OUT21/9450

**Bowden's Silver Project (SSD-5765)
Response to Submissions (RTS)**

Detailed advice to DPIE Planning & Assessment regarding the Bowden's Silver Project (SSD-5765) Response to Submissions (RTS)

**Figure 1 Modelled scenarios for final void filling**

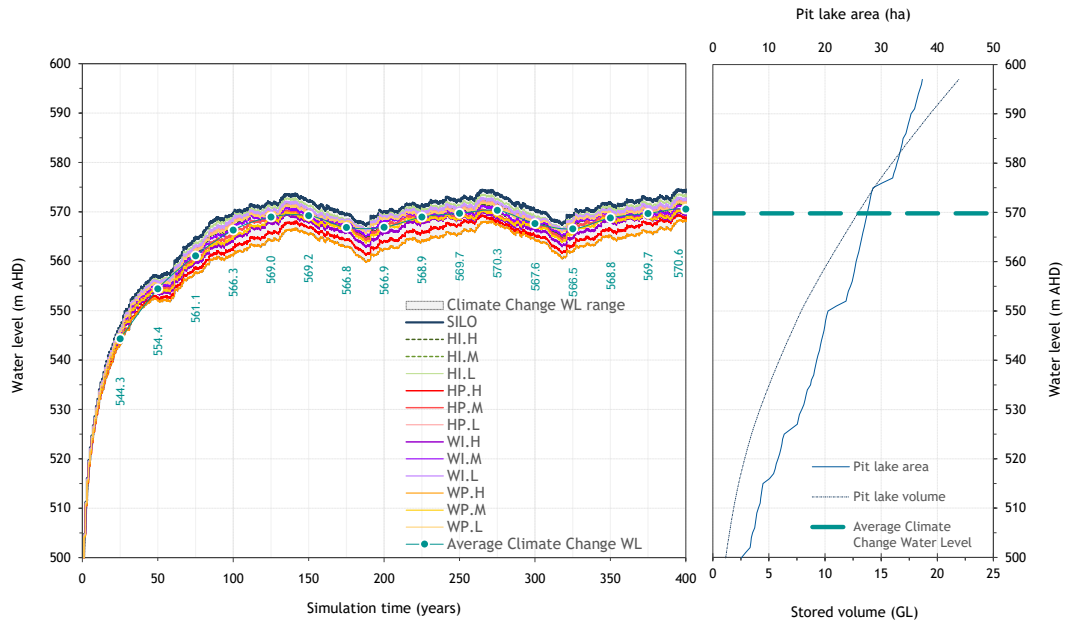
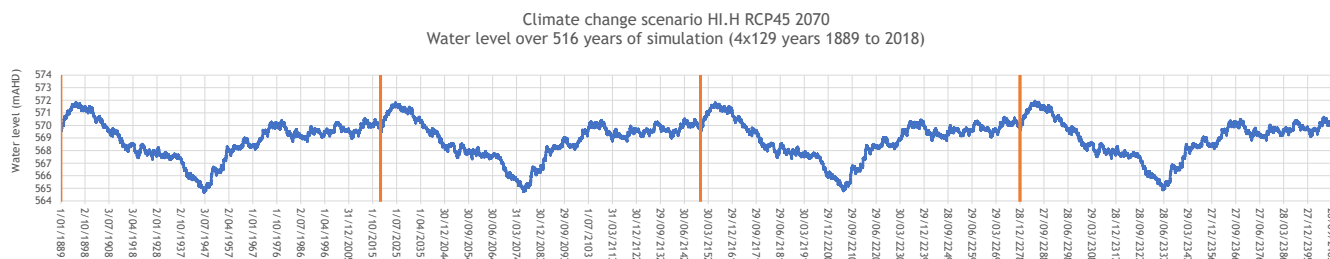
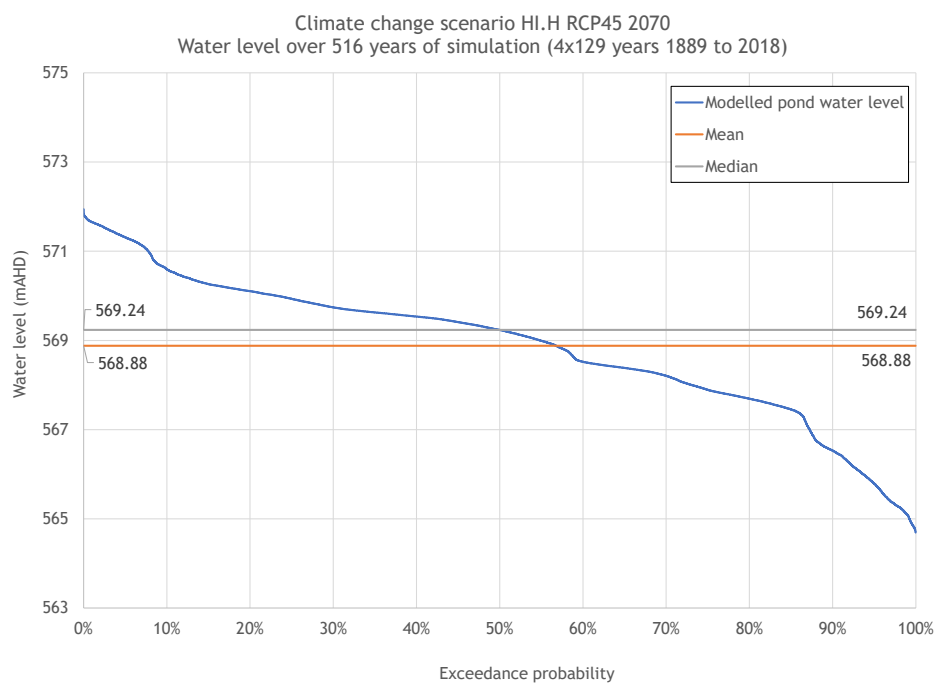
Insufficient information has been provided on the proposal to redirect catchment runoff into the void at mine closure to enable confirmation of potential water licensing requirements. The RTS has acknowledged the need to ensure the water take is consistent with licensing requirements which is supported. The ability to account for the surface water take where required will be critical in understanding the viability of the proposal to reduce the time for the pit lake to reach equilibrium, and to confirm any changes to predicted groundwater and surface water impacts after mine closure. Whilst it is understood this proposal would be further investigated near mine closure it is recommended further consideration be given now of how it fits within the water regulatory framework.

- Finalise agreements with external water supply providers to ensure adequate water supply can be made available when required. It is recommended this include consideration of options if the project approvals for these mines lapse during the life of this project.
- Provide further detail on the proposed sources and volumes of water to reduce the time for the pit lake to reach equilibrium after mine closure. The ability to obtain any water entitlements should be demonstrated.
